June 8, 2022

Subject: **Response to Geotechnical Peer Review Comments Regarding
2204-107-SUB1-PLANS**

Proposed Mercer Island Treehouse Residence
5637 East Mercer Way
Mercer Island, Washington

FOUNDATION PLAN

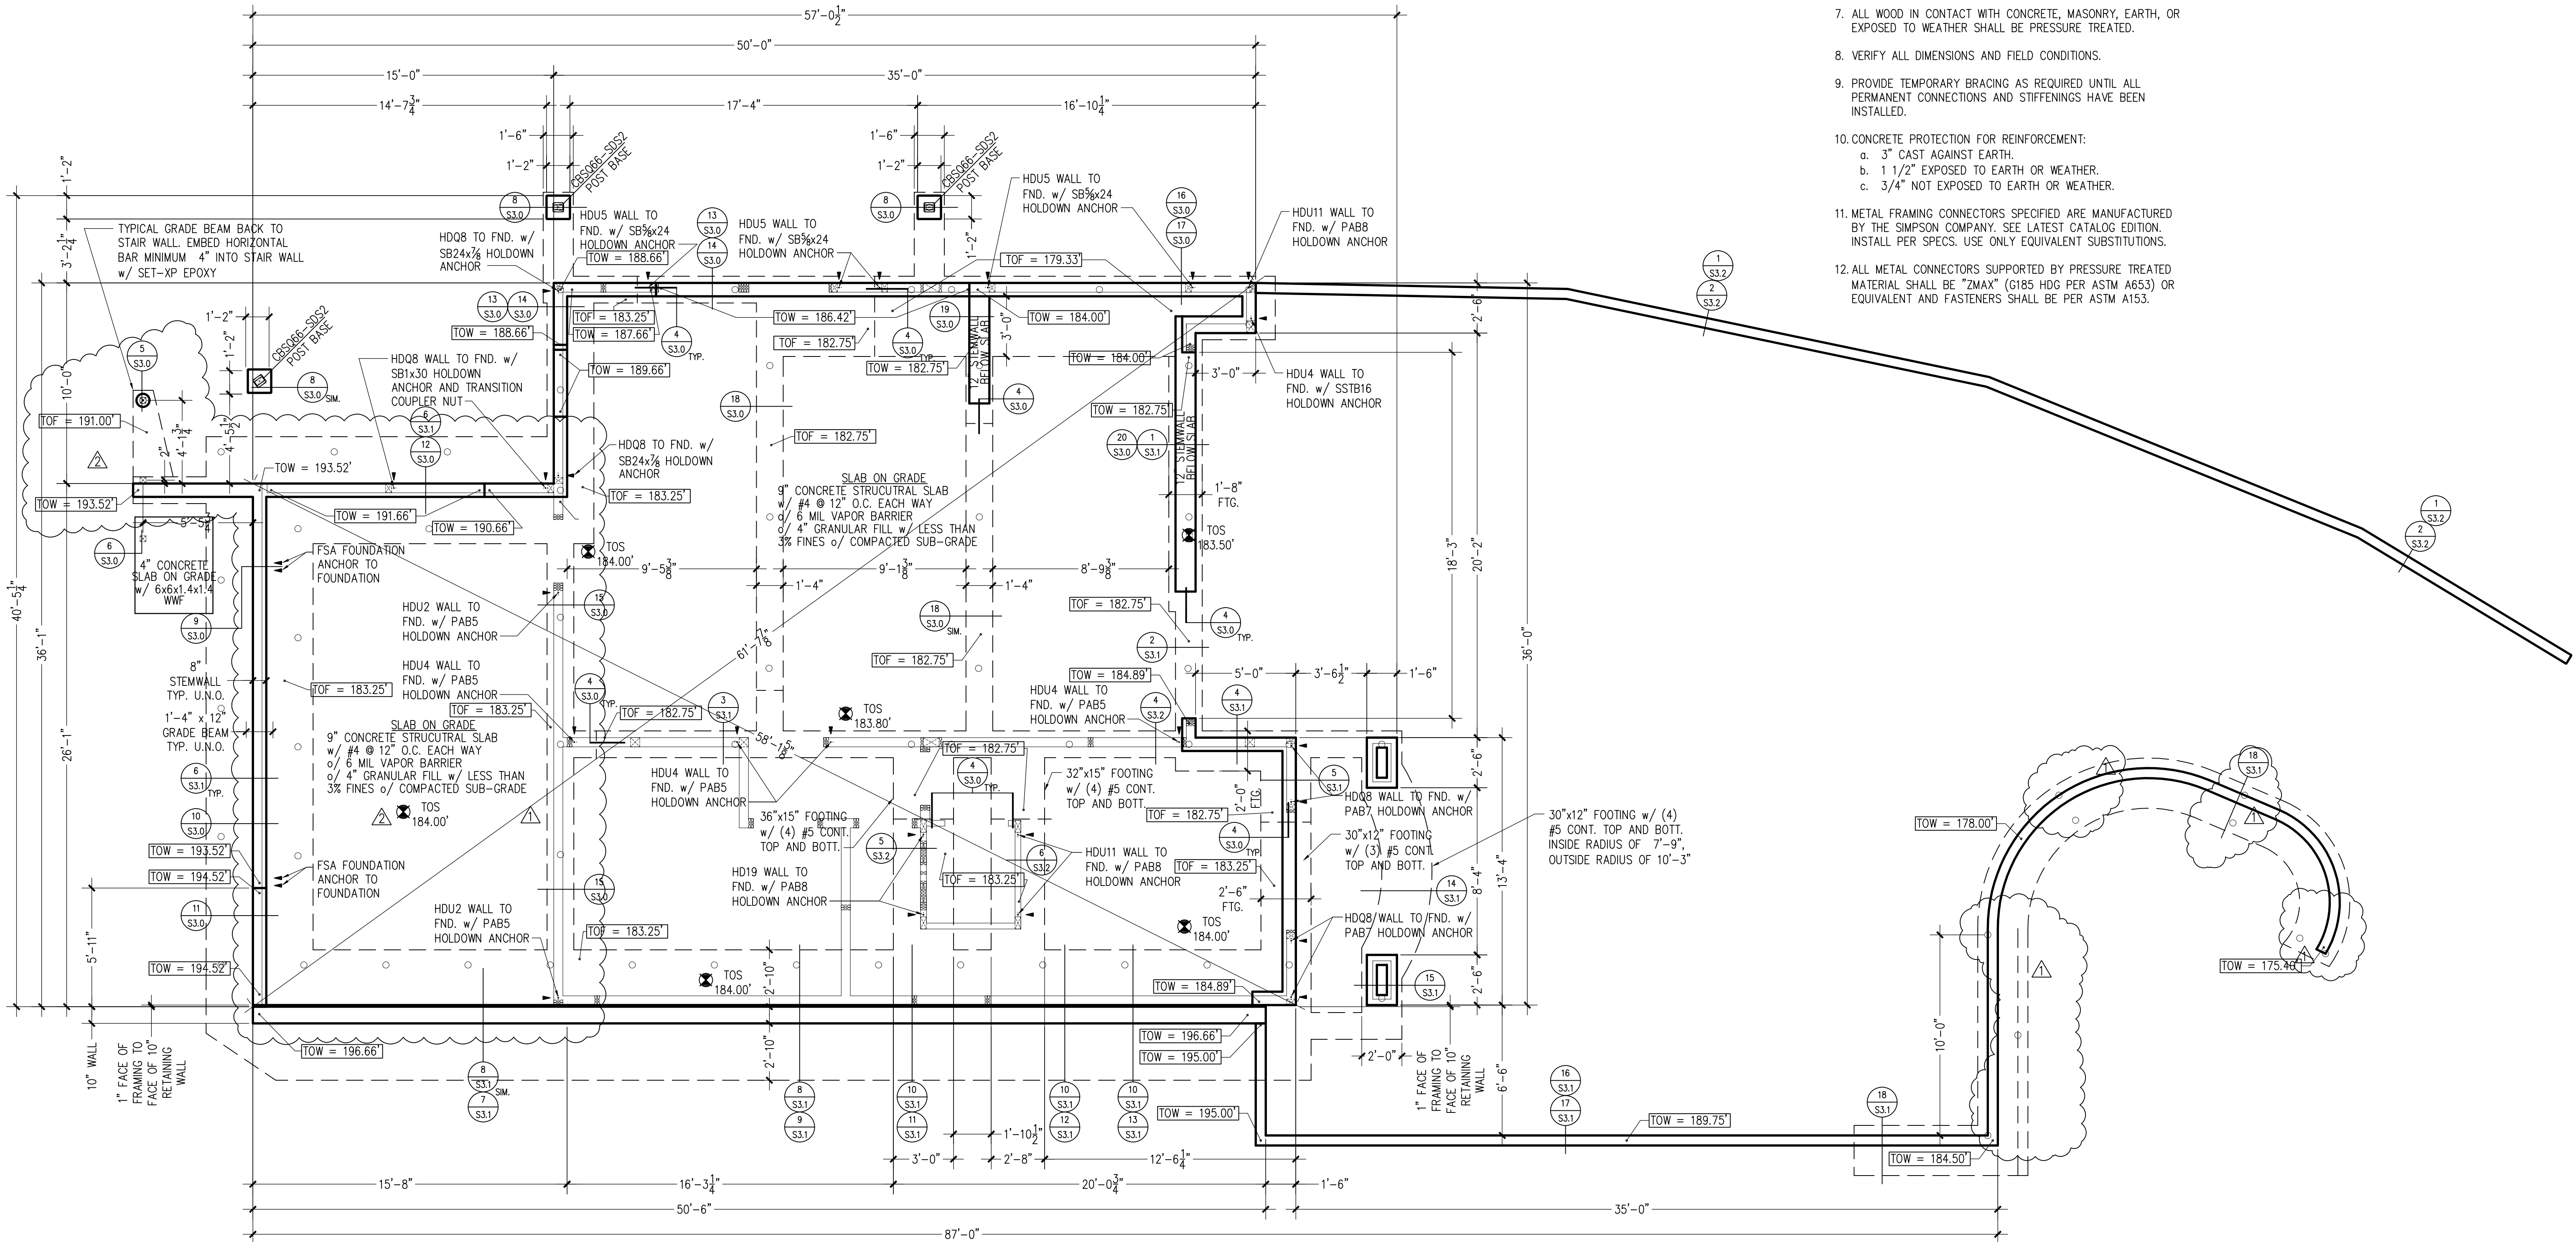
Number: 1 *The geotechnical report recommended a structurally supported slab. Resolve discrepancy.*

Number: 4 *The geotechnical report did not recommend shallow foundations but the use of pin piles or helical anchors for foundation support. Resolve discrepancy. Verify that retaining walls are designed for seismic loading.*

Response: The note on S2.0 clearly indicates that the concrete floor slab would be a structural slab that will span between the pile-supported foundations. The slab is 6 inches thick and reinforced with a mat of rebar. The term "Slab On Grade" used before "6" Concrete Structural Slab" simply refers to the fact that the structural slab will be poured on soil, rather than being elevated.

There is no need to modify the plan for this item.

Response: The upper soils are loose, wet sands and should not be depended on to support retaining walls more than a few feet in height. Based on the expected heights of the walls to be installed along the south side of the driveway, they should be supported on piles.

The structural plans will be modified accordingly.

SITE PLAN

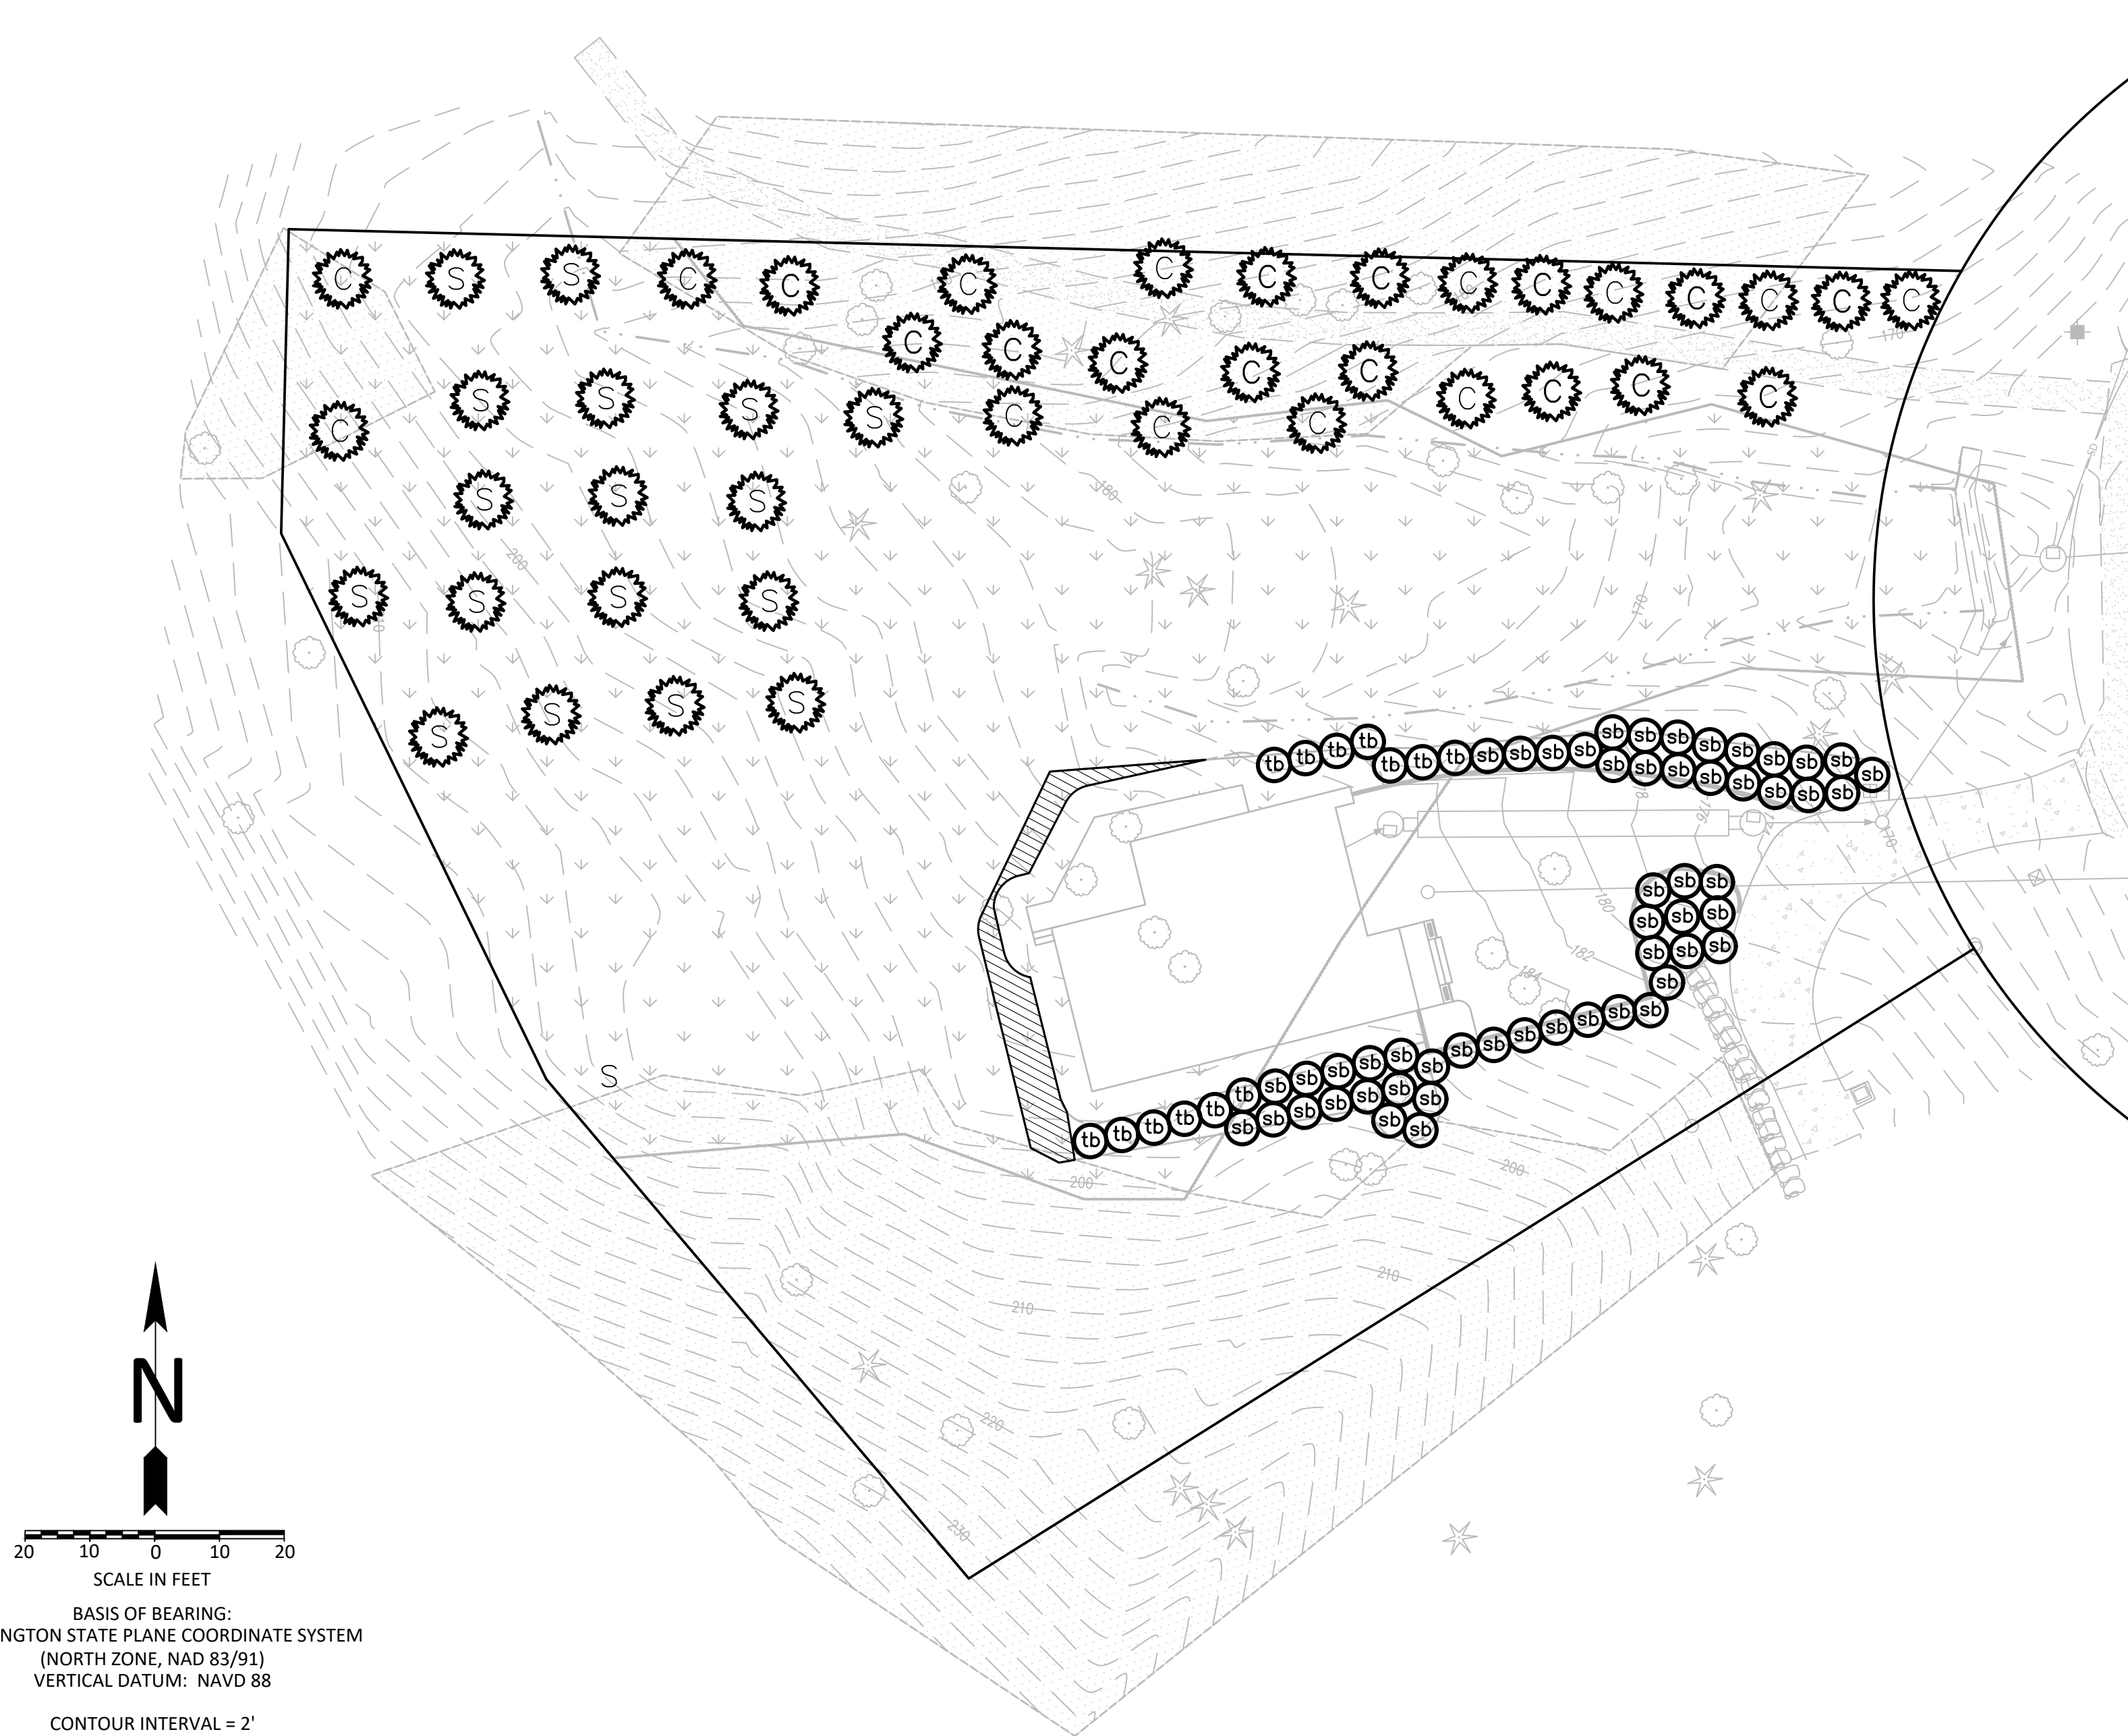
Number: 1 *Geotechnical engineer to review the proposed plantings in the steep slope areas and identify potential negative impacts of proposed plantings with respect to stability of the slopes. Provide recommendations for mitigation of potential negative impacts, if appropriate. Revise plan accordingly.*

Response: The provided plans indicate that trees (cedars) would be planted on the steep slope areas to the west and south of the planned residence. While evergreen vegetation on steep slopes can provide some stability benefits through precipitation interception, it is our professional geotechnical opinion that this should be limited to low-growing evergreen vegetation. Trees should not be planted on steep slopes, particularly upslope of existing or proposed occupied structures. Planting the trees requires excavation that will disturb the slopes. The holes created to plant the root balls will tend to collect water, which will decrease shallow slope stability. More concerning is the dead weight that will result from the trees for a substantial length of time until they are deeply rooted into dense soil. Additionally, in the event of potential future slope instability, the trees increase the risk of substantial damage to the residence and pose a real risk to the occupants. This risk increases as the trees become larger and heavier.

We recommend the following:

1. Minimize the number of trees to be included in any wetland restoration on the site, and place them only in areas away from steep slopes and the planned development area.
2. Maximize the use of low-growing evergreen plants that would be water-loving.
3. Utilize live staking as much as practical to plant amongst existing vegetation and brush outside of the areas close to the planned development area.
